From: [George Howlett](#)
To: [Aquind Interconnector](#)
Cc: [David Conboy](#)
Subject: Written Summary - Compulsory Acquisition Hearing 2 (11th December 2020)
Date: 18 December 2020 11:51:11
Attachments: [2020.12.18 - Response to Planning Inspector.pdf](#)

**Re: Application by AQUIND Limited for an Order Granting Development Consent for the
AQUIND Interconnector Project**

Ref: EN020022

We write following our attendance of the Compulsory Acquisition Hearing 2 (11th December 2020) on behalf of Sainsbury's Supermarkets Limited ('SSL') in respect of the above Development Consent Order ('DCO'). The purpose of this letter is to summarise the points made in the hearing in respect of SSL's objection to the acquisition of new rights over a significant area of the car park at Sainsbury's Supermarket, Fitzherbert Road, Portsmouth, PO6 1RR ('Sainsbury's Farlington'). SSL hold the freehold interest in Sainsbury's Farlington.

4.4. ZETLAND FIELD

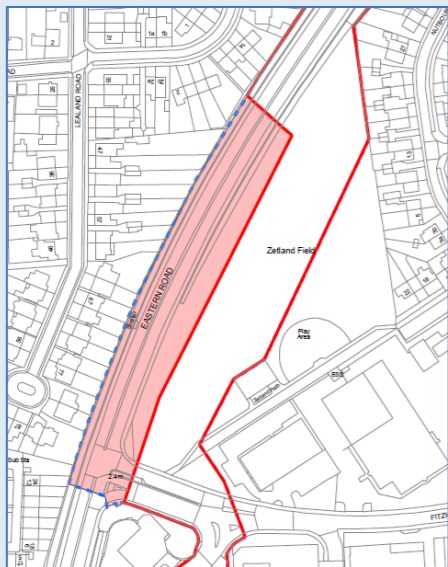
As explained at the hearing, AQUIND's proposal to excavate and lay cables across the entire length of the Sainsbury's Farlington store's car park contravenes one of the strategic principles of the scheme as set out in the Environmental Statement, namely that the onshore cable route would be laid in the highway. It also goes against the criteria that there should be minimal impact on the landowners and occupiers which was reportedly adopted when selecting a cabling route.

AQUIND has advanced that it is necessary to utilise private land in this location due to the existence of the elevated section of railway and the preference to extend the cabling route underneath the railway rather than place cables over it. We appreciate there is logic in this given the presence of operational railway infrastructure, but if this necessitates the cabling route passing through a part of the Sainsbury's Farlington store's car park, it does not provide any form of

justification for it extending across the entirety of the car park. It is SSL's position that the cabling route positioned within the car park land should be rationalised as much as possible so to: (i) minimise the impact to the store and the business, and (ii) reduce the amount of land which is sterilised from any future development as a consequence of the existence of the cable. AQUIND's proposed cabling route extends along the entirety of the customer car park's access road which is the sole access to the store from the public highway. The works will result in a significant interference with customer access, an interference which is avoidable.

As presented at the hearing and as shown at Appendix 1, assuming that it is necessary for the cabling route to enter the Sainsbury's Farlington store's car park at its southern boundary, it is entirely feasible that the cabling route could only extend through the southern part of the car park, utilising the reduced level change between the car park and the adopted highway to direct the cabling route into the public highway at this location. As shown in the photographs at Appendix 2, there is a ramped pedestrian footpath that provides access between the store and the public highway and this route can be utilised to move the cabling into the adopted highway. This option has the advantages of: (i) minimising the incursion of the cabling route into private land as per the strategic principles of the scheme, (ii) minimising the disruption to Sainsbury's operations, and (iii) reducing the amount of land which is sterilised as a consequence of the cabling route (which based on experience will likely extend 3-6m from the centre line of the cable route).

In the hearing we repeated our concerns that the Order Limit is far too extensive and unreasonable. The extent of the land over which new rights are sought totals 12,279 sq. m and includes the store's sole customer access from the public highway, the entire length of the car park's principal access and circulation road, the car wash, landscaped areas, several rows of car parking and the store's recycling centre.
